### **Crystal Park Site S-122(AR), CP-24-6**

Please accept the following comments from El Paso County Public Health regarding the project referenced above:

- **Crystal Park Site S-122, 6881 Eagle Mountain Road, is a residential development site that will be served water by an individual private well and wastewater through an on-site wastewater treatment system (OWTS).**

**SP1**

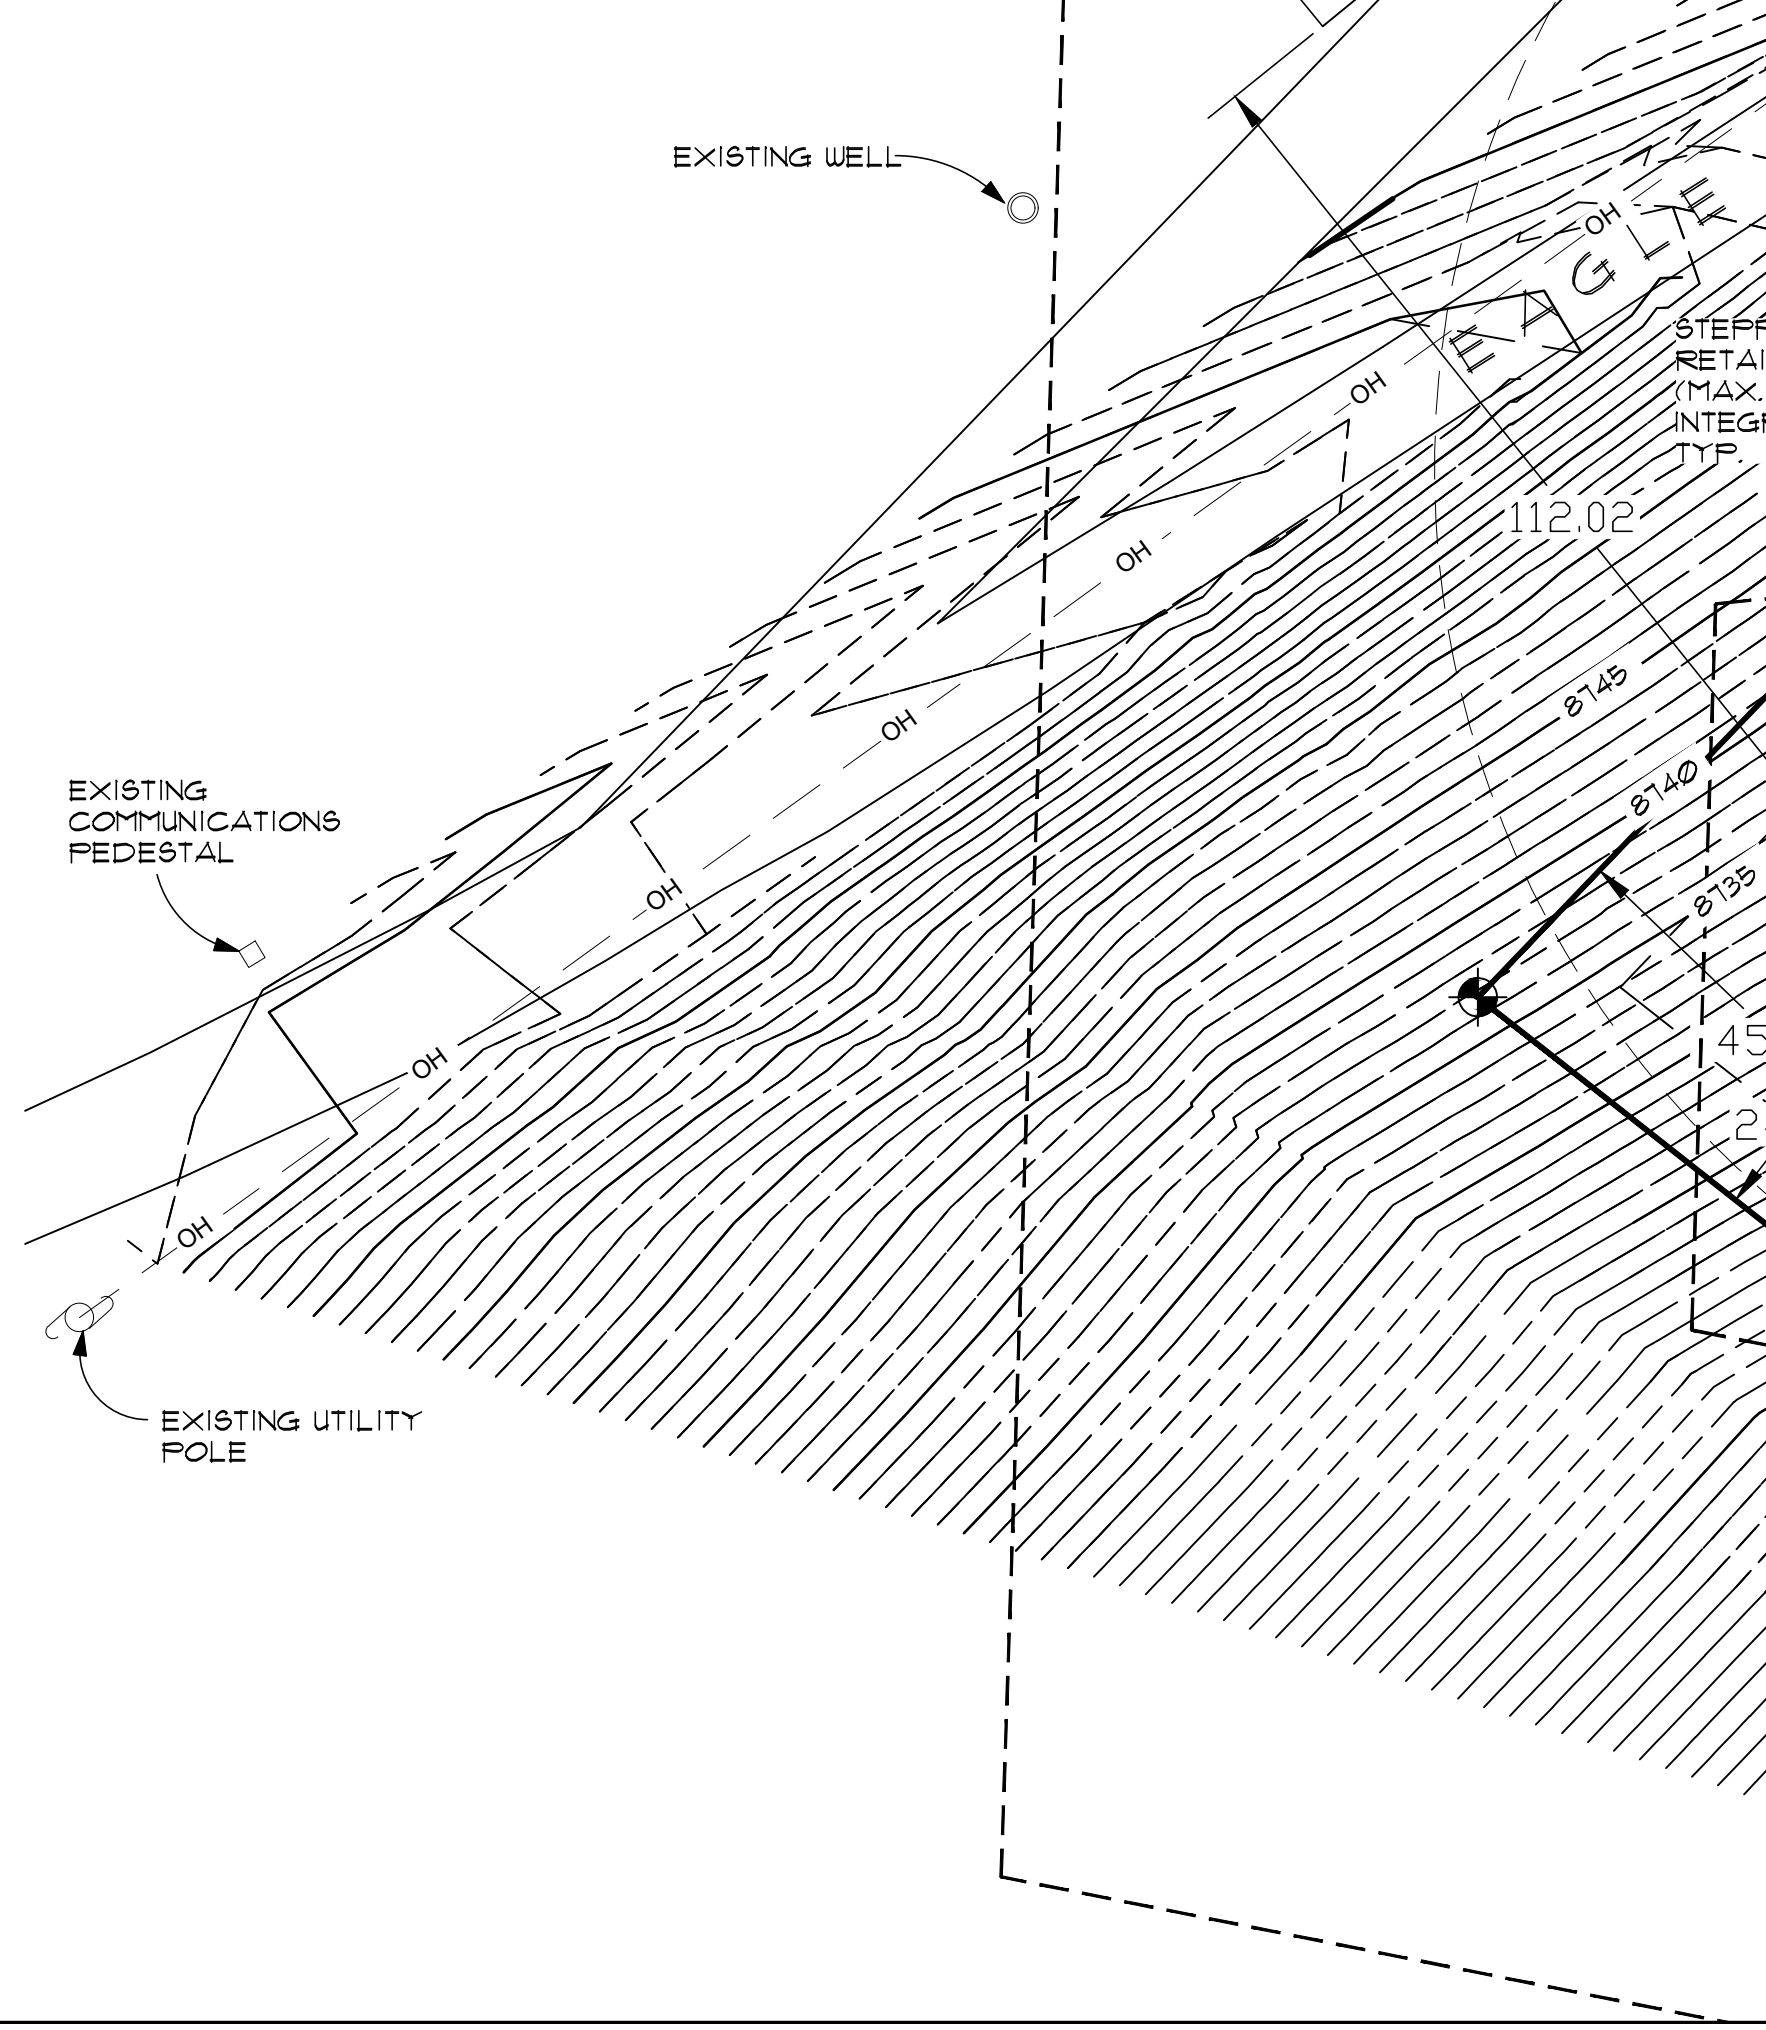
- **The site development plan indicates locations for both a primary and secondary soil treatment area (STA). The OWTS must meet all current El Paso County Public Health OWTS Regulations including OWTS permit approval. The results of the soil tests in these areas will determine the types of STA's to be considered for approval.**

- **The OWTS areas must be 100' minimum from any well, internal or external, and the primary and secondary soil treatment areas must be protected from all house construction and site development activities.**
